SSD-10461: Valley of the Winds, Warrumbungle Shire Council

3 August 2022

TfNSW has reviewed the documentation including (but not limited to) the *Traffic Impact Assessment* (TIA), prepared

VALLEY OF THE WINDS		
GOLDEN HWY / LEADVILLE ACCESS ROAD INTERSECTION DETAIL PLAN SHEET 2 OF 2		
PROJECT NO RTE-220034	SHEET NO SHT-52-RW-0102	STATUS STRATEGIC DESIGN

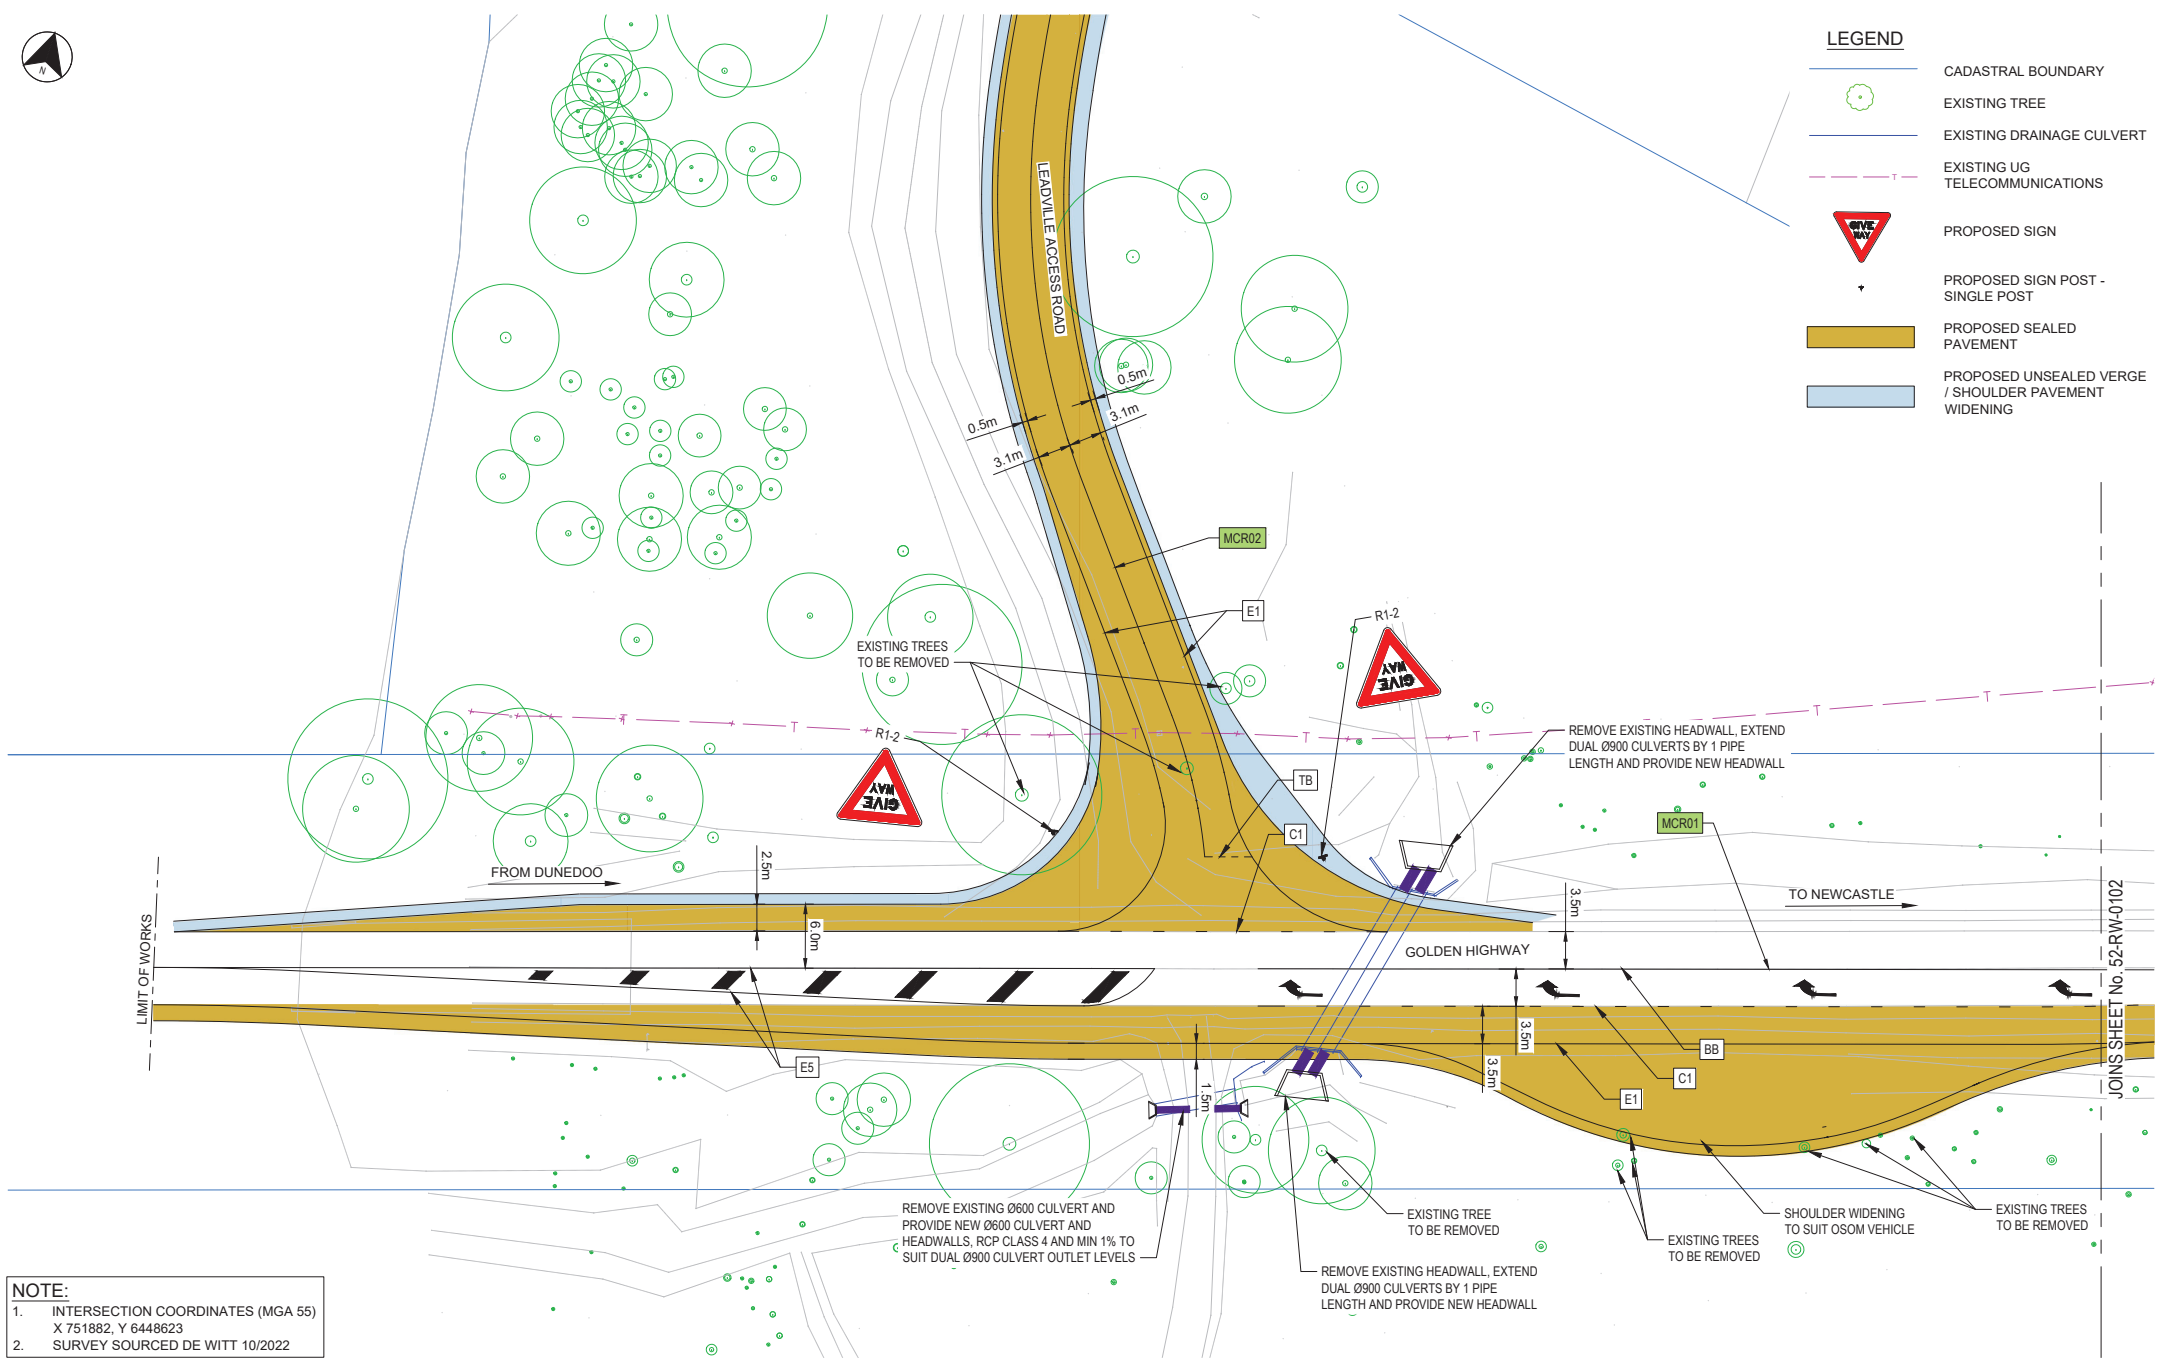
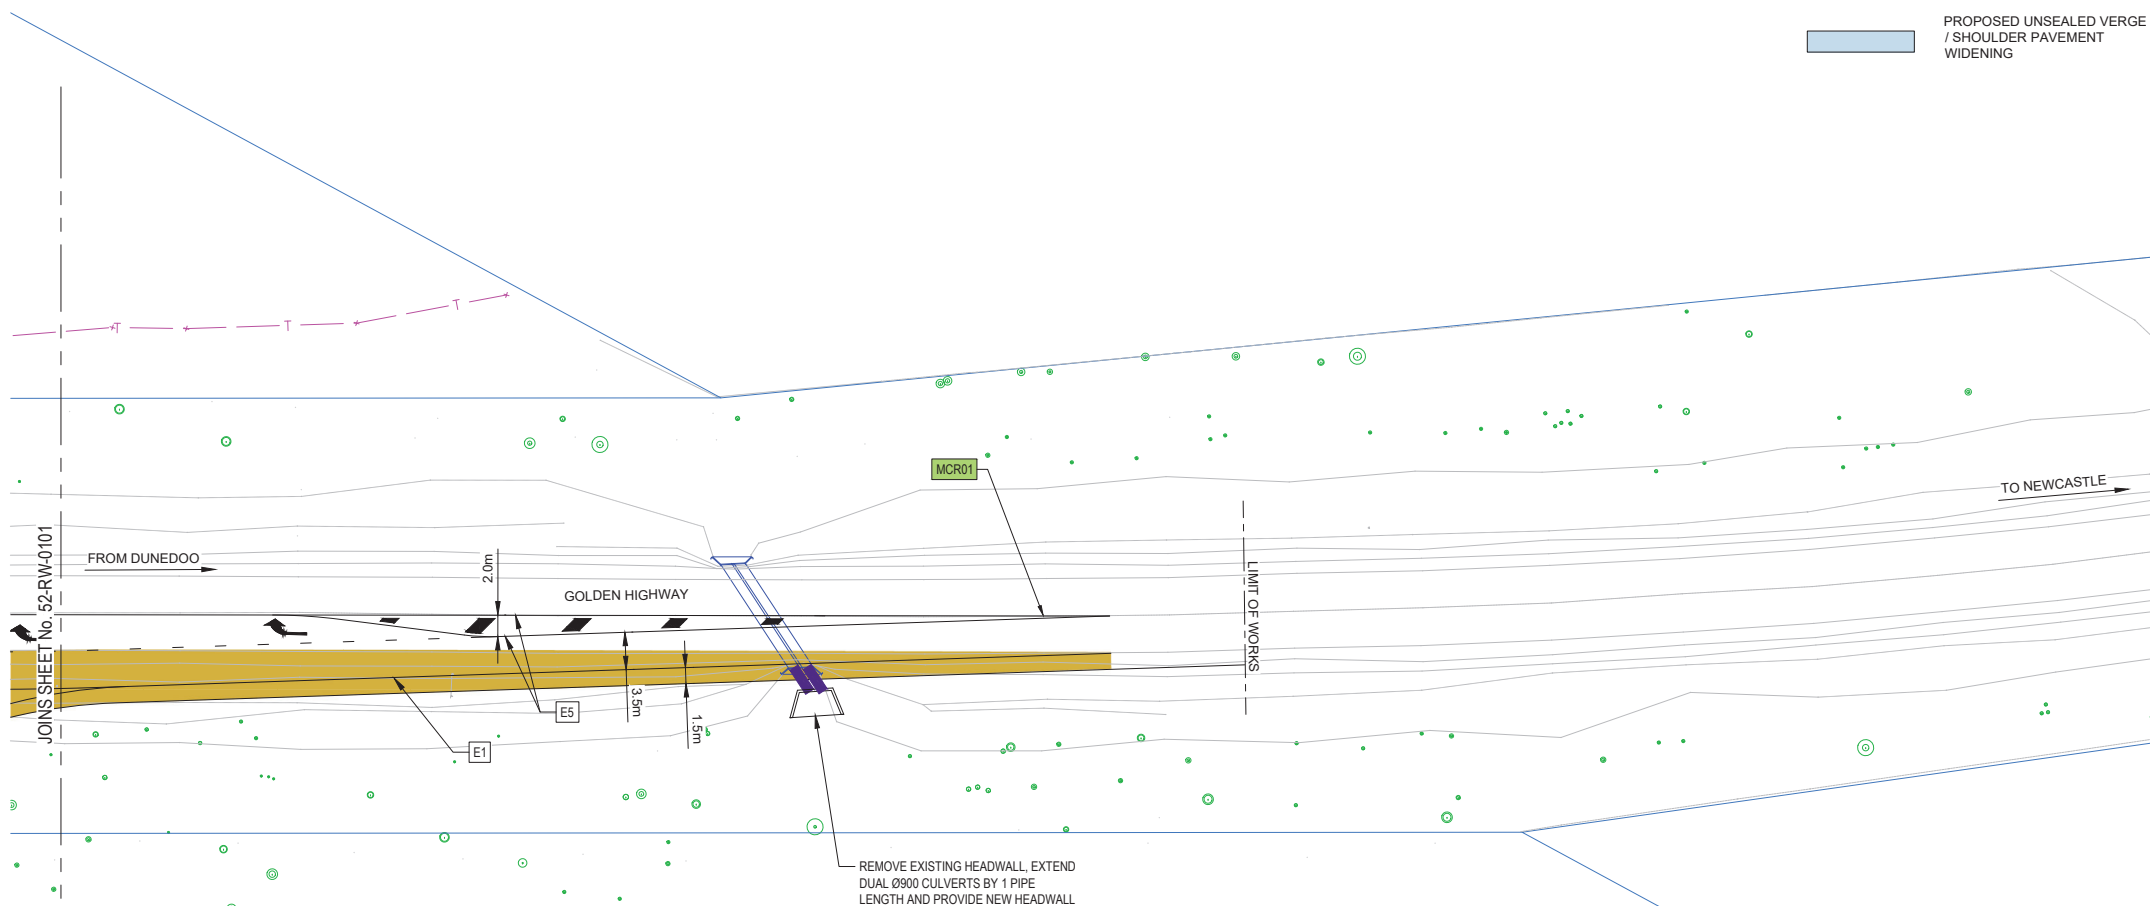
- Reconsideration of the proposed minimum BAR/BAL intersection treatments along the Golden Highway, noting the high percentage of heavy vehicle traffic on the major freight route and the high-speed limit (i.e. 85th percentile is likely to be higher on the rural road than the signposted speed). The TIA shows that right-turns associated with AM peak construction traffic at the Golden Highway / Leadville Access (both access locations for Leadville cluster) and Golden Highway / Short Street (Girragulang cluster) are considerably greater than existing traffic movements.
